Planning and Development Service
Economy and Infrastructure PO Box B93,
Civic Centre 3,
Off Market Street,
Huddersfield,
HD1 2JR

22 November 2021

RE: Objection to planning application 2021/62/91871/E – Hanging Heaton

FLOOD ROUTING LAYOUT

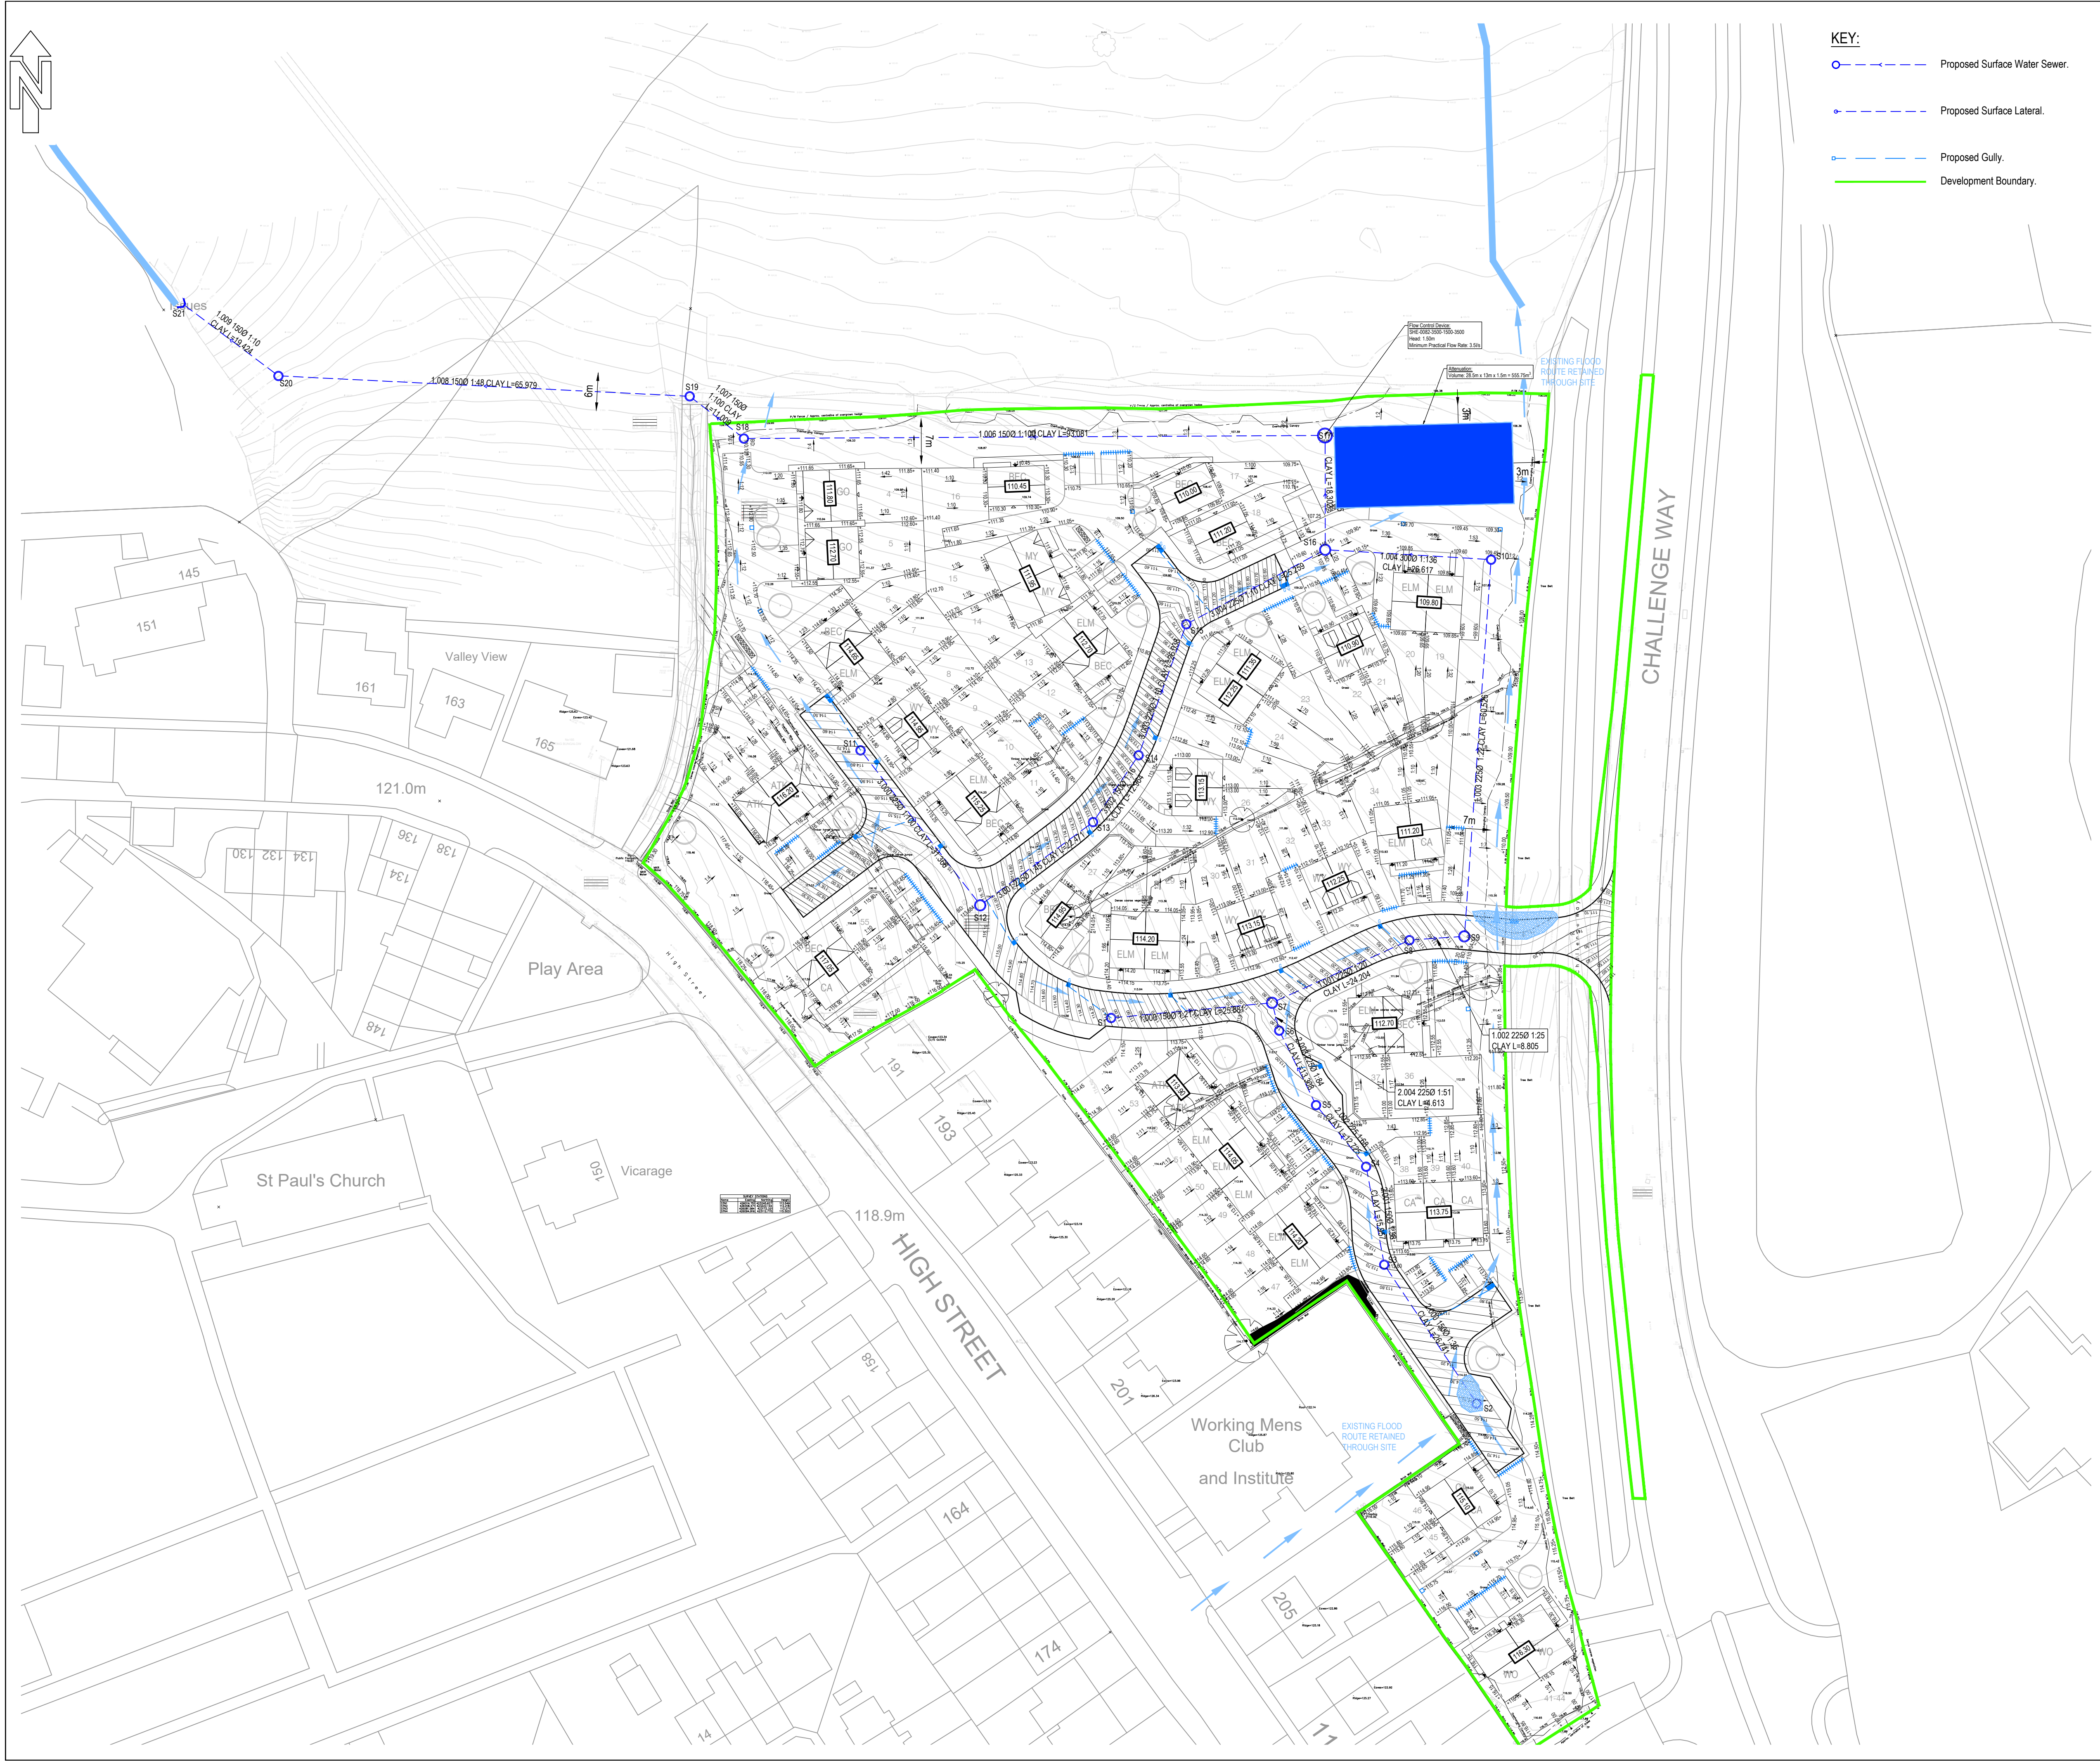
We note the comments on drainage, flooding and water courses which seek to reflect the reasons for the Committees deferral. However, we maintain that insufficient information has been submitted to fully appreciate these issues and we urge the Lead Local Flood Authority, who we trust have been re-consulted following the deferral, to forensically analysis the information along with the comments we made in our original objection and those made orally at the committee. We await sight of their considered comments once they have been provided.
